Remodelling of roof to form 1 No. dormer to rear elevation, 2 No. dormers to front elevation, 1 No. dormer to side elevation, front & side extensions.

29 Willowhale Avenue Aldwick

Thank you for your internet representation made on 13th November 2017 which has been recorded as '**an objection**' with the comments as follows:

Proposed Rear Elevation 1:100

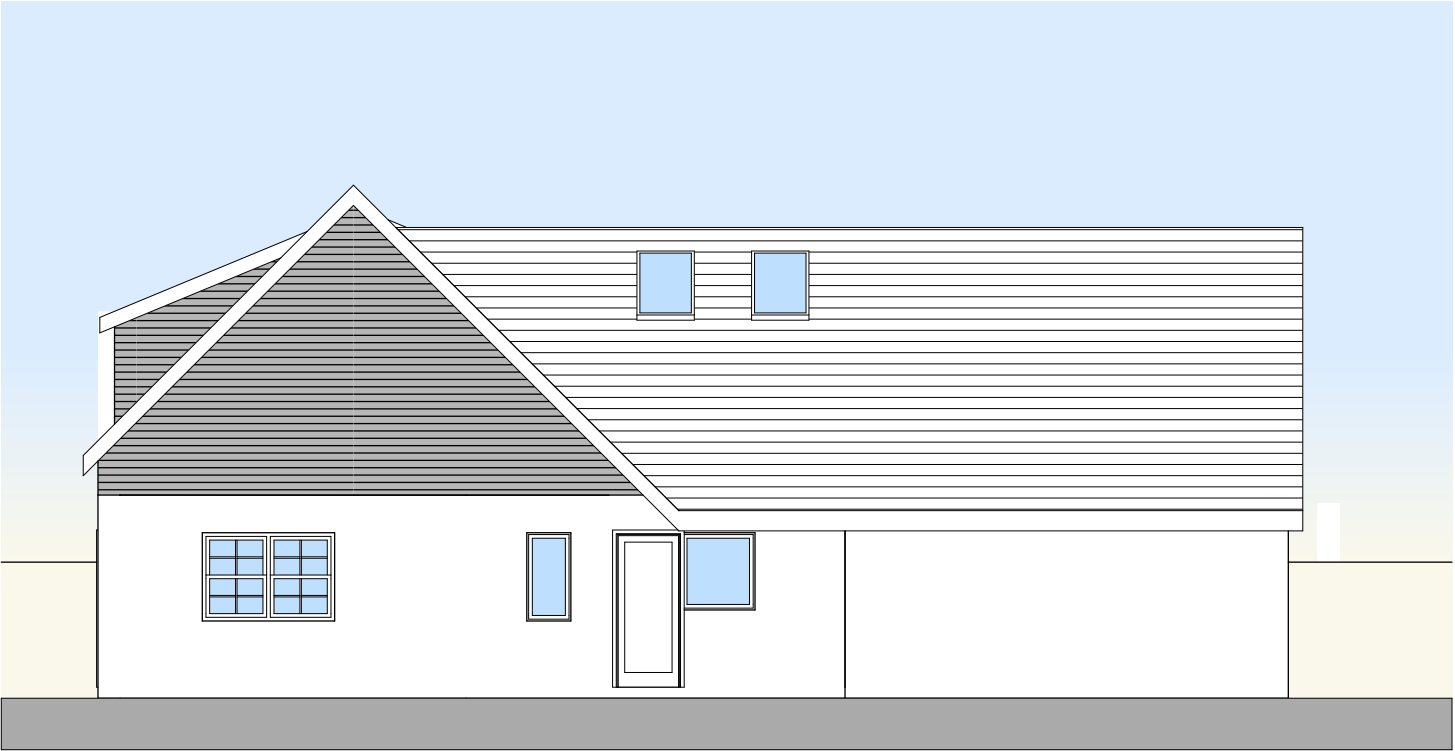
- 1. The proposed position of the new double garage with living accommodation above extends to far forward of the existing Building line of the properties in this section of Willowhale Avenue, and will make the visual street seem out of keeping with the existing line.*
- 2. The side extension and front extension roofs will have a detrimental effect on the next door property ie No 27 Willowhale Avenue as the distance from the new structure will only be 1 metre from the boundary and only 2 metres from the south elevation of this property, The gable end of the new side extension is for full height of the building and this will be more overpowering than the remainder and this will restrict the southerly light and sun to the living accommodation of No 27.*
- 3. The proposed large Dormer window on the rear elevation, may be functional, but architecturally it is not very pleasing to the eye.*
